DRB Project Number: 2022-006746
1748, 1752, 1756 Cliffside

SUBJECT: Sketch

Project: Lots A-26 & A-24-A, Vista Magnifica Subdivision Agenda Item No: 2

REQUEST: PROPOSED REPLAT OF LOTS A24, A25, A26 IN VISTA MAGNIFICA SUBDIVISION. GOAL: TURN CURRENT THREE LOTS INTO TWO LOTS, AND FACING NEW DIRECTIONS

PLAT OF SURVEY
LOTS A24, A25 & A26, BLOCK 4
VISTA MAGNIFICA SUBDIVISION
CITY OF ALBUQUERQUE
BERNALILLO COUNTY, NEW MEXICO

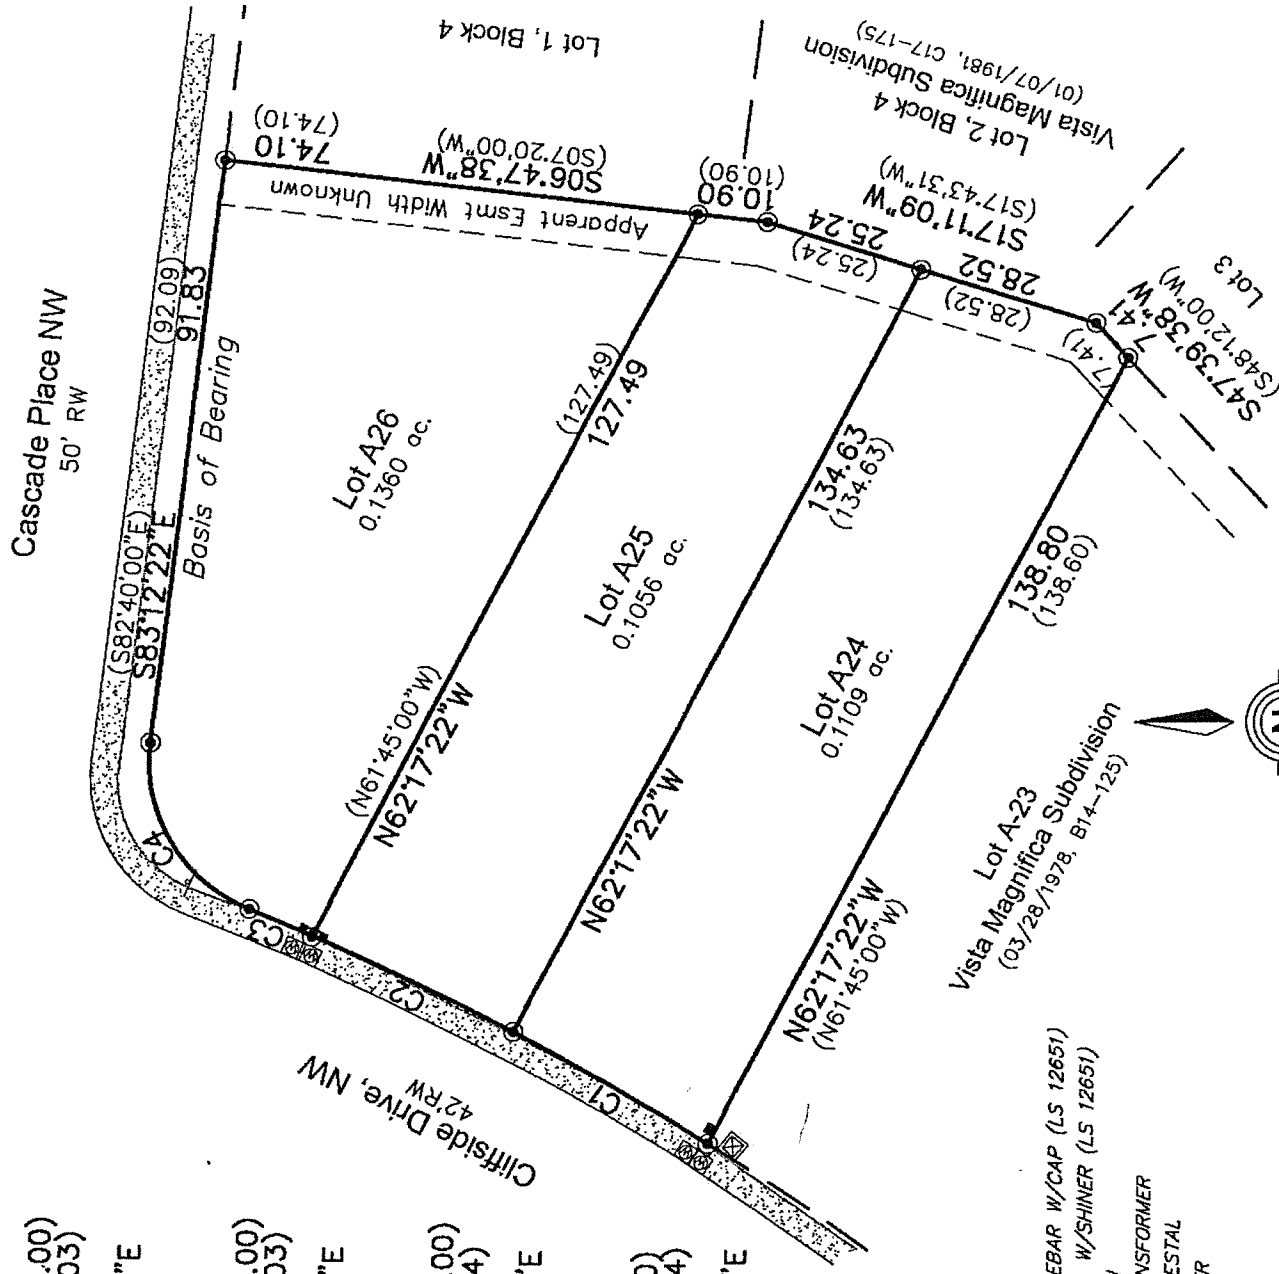
1. Both Cliffside and Cascade are considered local roads and a minimum 48-foot wide right-of-way is required. Cliffside Drive shows a 42-foot wide right-of-way. Right-of-way dedication is required or a justification letter is needed for a waiver to allow it to remain at current width.
2. 5' sidewalks with a 4-6' landscape buffer is required along both roadways. Please provide dimensions of existing sidewalk on Cliffside. Sidewalk construction is required along Cascade. All construction items in the right-of-way need to be placed on an infrastructure list and financially guaranteed.
